**NOTICE OF VIOLATION AND ORDER TO CORRECT**

<b>Location</b> 30 DEERING ST	<b>CBL</b> 046 C001001	<b>Inspection Date</b> 3/7/2016
<b>Inspector</b> Michael Nixon	<b>Inspection Type</b> FP Routine Inspection	<b>Status</b> Failed

BASEMENT

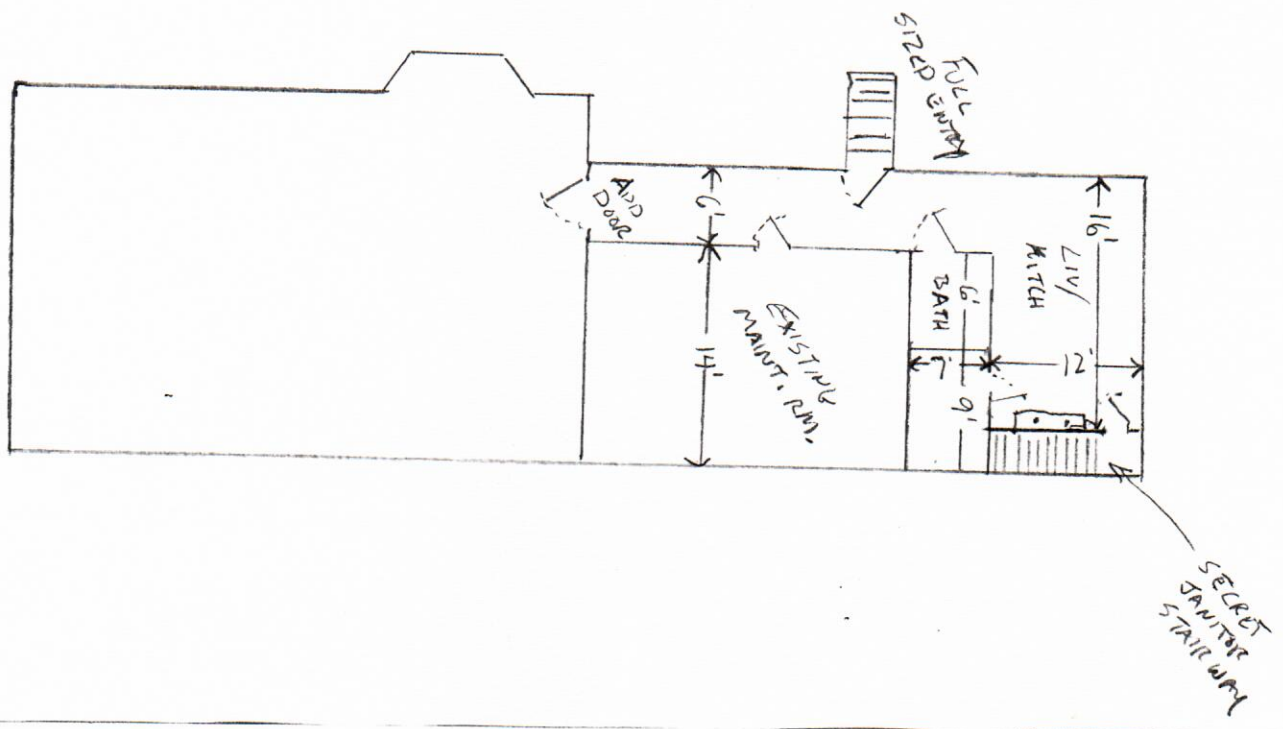
<b>Violation</b>	<b>Proposed Date of Completion</b>
<b>NFPA 101- 7.2.1.15.8 FIRE DOOR ASSEMBLY REQ REPAIR;</b> Door openings not in proper operating condition shall be repaired or replaced without delay. One furnace room has a fire door that needs a self closer	11 / 30 / 17
<b>NFPA 10- 7.2.4.4 FIRE EXTINGUISHER INSPECTION TAG;</b> Where manual inspections are conducted, records for manual inspections shall be kept on a tag or label attached to the fire extinguisher, on an inspection checklist maintained on file, or by an electronic method. In the basement(some)	10 / 30 / 17
<b>NFPA 101- 9.7.4.1 FIRE EXTINGUISHERS REQ- OTHER;</b> Where required by the provisions of another section of this code, portable fire extinguishers shall be installed, inspected, and maintained in accordance with NFPA 10, Standard for Portable Fire Extinguishers. Extinguishers need to be mounted (in several areas)	10 / 30 / 17

<b>NFPA 101- 31.3.4.5.1 SMOKE ALARMS REQUIRED;</b> In buildings other than those equipped through out with an existing, complete automatic smoke detection system, smoke alarms shall be installed in accordance with 9.6.2.10, as modified by 31.3.4.5.2, outside every sleeping area in the immediate vicinity of the bedrooms and on all levels of the dwelling unit, including basements. Detector 110 is damaged	10 / 30 / 17
<b>NFPA 101- 8.3.4.2 60 MINUTE FIRE DOOR REQUIRED;</b> Refer to NFPA 101- Table 8.3.4.2 that states fire door assemblies for vertical shafts (including stairways, exits, and refuse chutes) are rated and required for 1 hour. Throughout... One furnace room has a hollowcore door	11 / 30 / 17
